Planning Application LU/386/17/PL
Land East of Torri House, Old Mead Road, Littlehampton

We are the owners and occupiers of Old Mead Nursery, and we have the following comments to make about the Application advertised as being made to the Council, in respect of land east of Torri House, Old Mead Road, Littlehampton.

Site Plan	
Date	November 2017
Scale	1 : 500 @ A3
Sheet	MJS/11-2017/ PL47-02

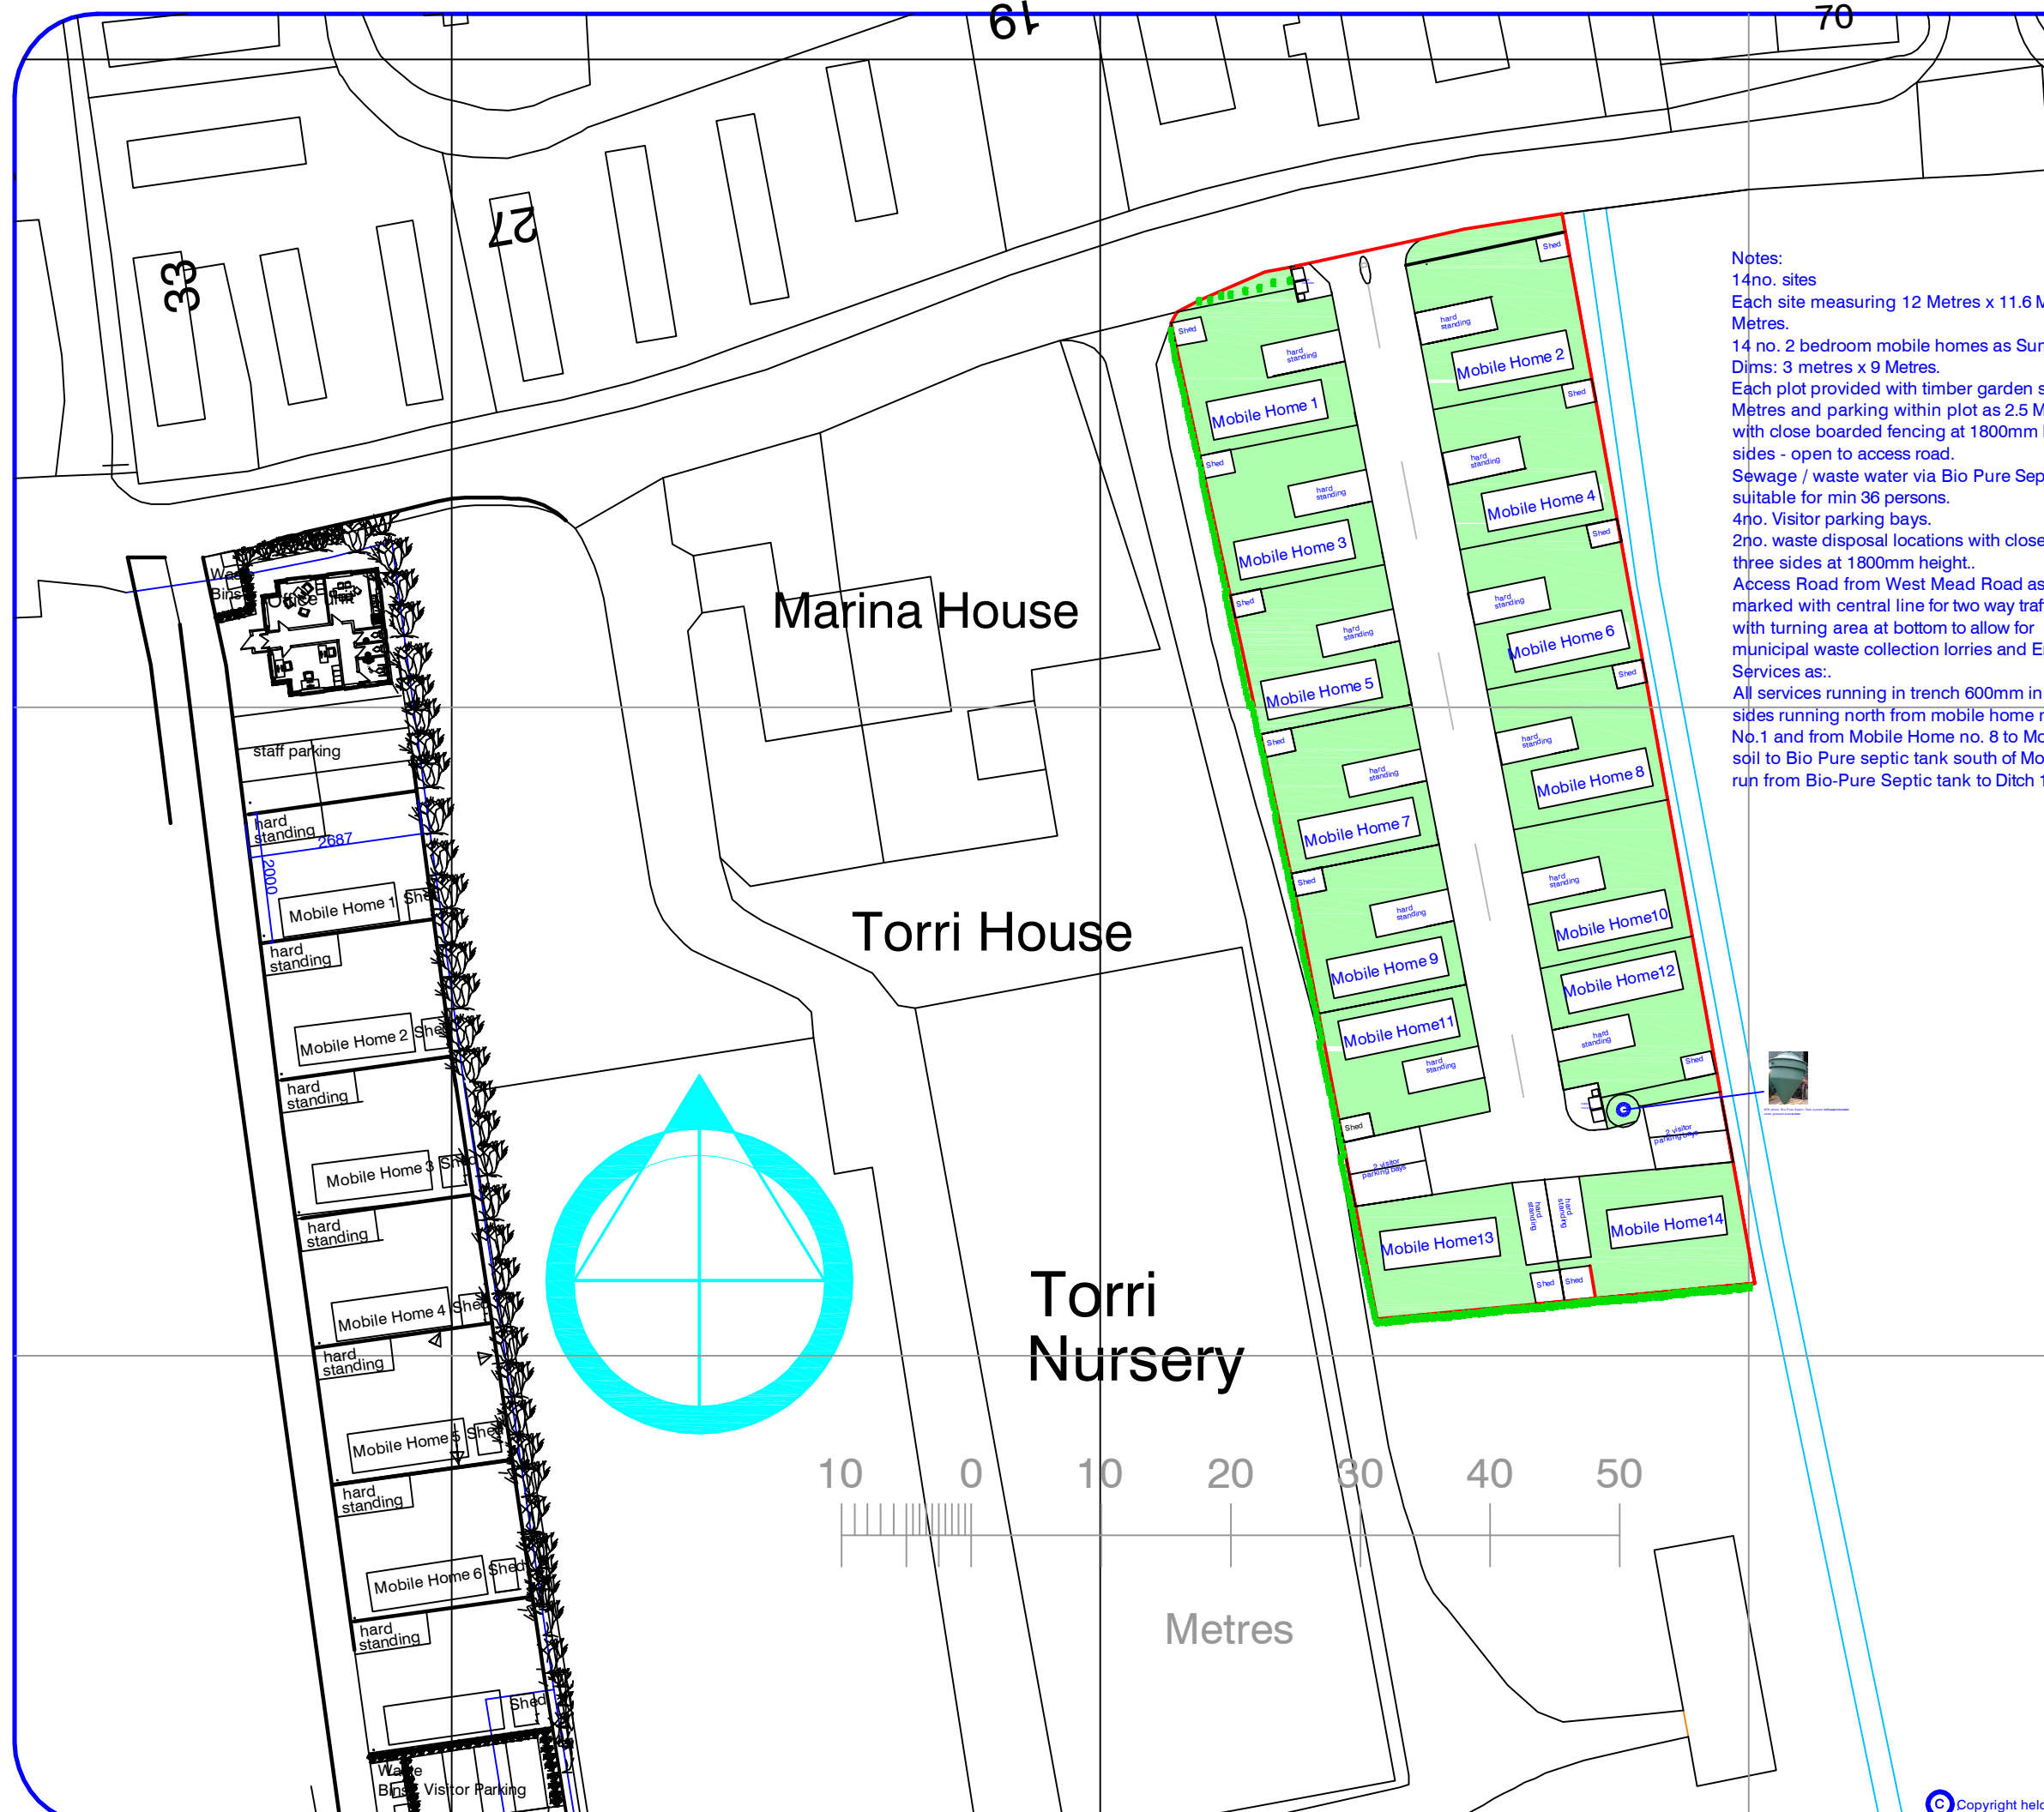
- 2) The land on which the proposed Mobile homes would be placed was raised above the adjoining land on all sides about thirty years ago, which means the effect of any overlooking onto our property would be greater than if at the same ground level, and the Mobile homes would also be on wheels so the floors would be even higher and would be more visible unless there was screening. We ask that permission should not be given to raise the ground any higher than it is.

- 3) We also ask that the Mobile Homes should not be allowed close to the boundary with Old Mead Nursery.
- 4) We are concerned about the possibility of drainage having an effect on our land, and ask that if permission is given it should be on condition that the approved land is properly drained so there is no danger to adjoining land.
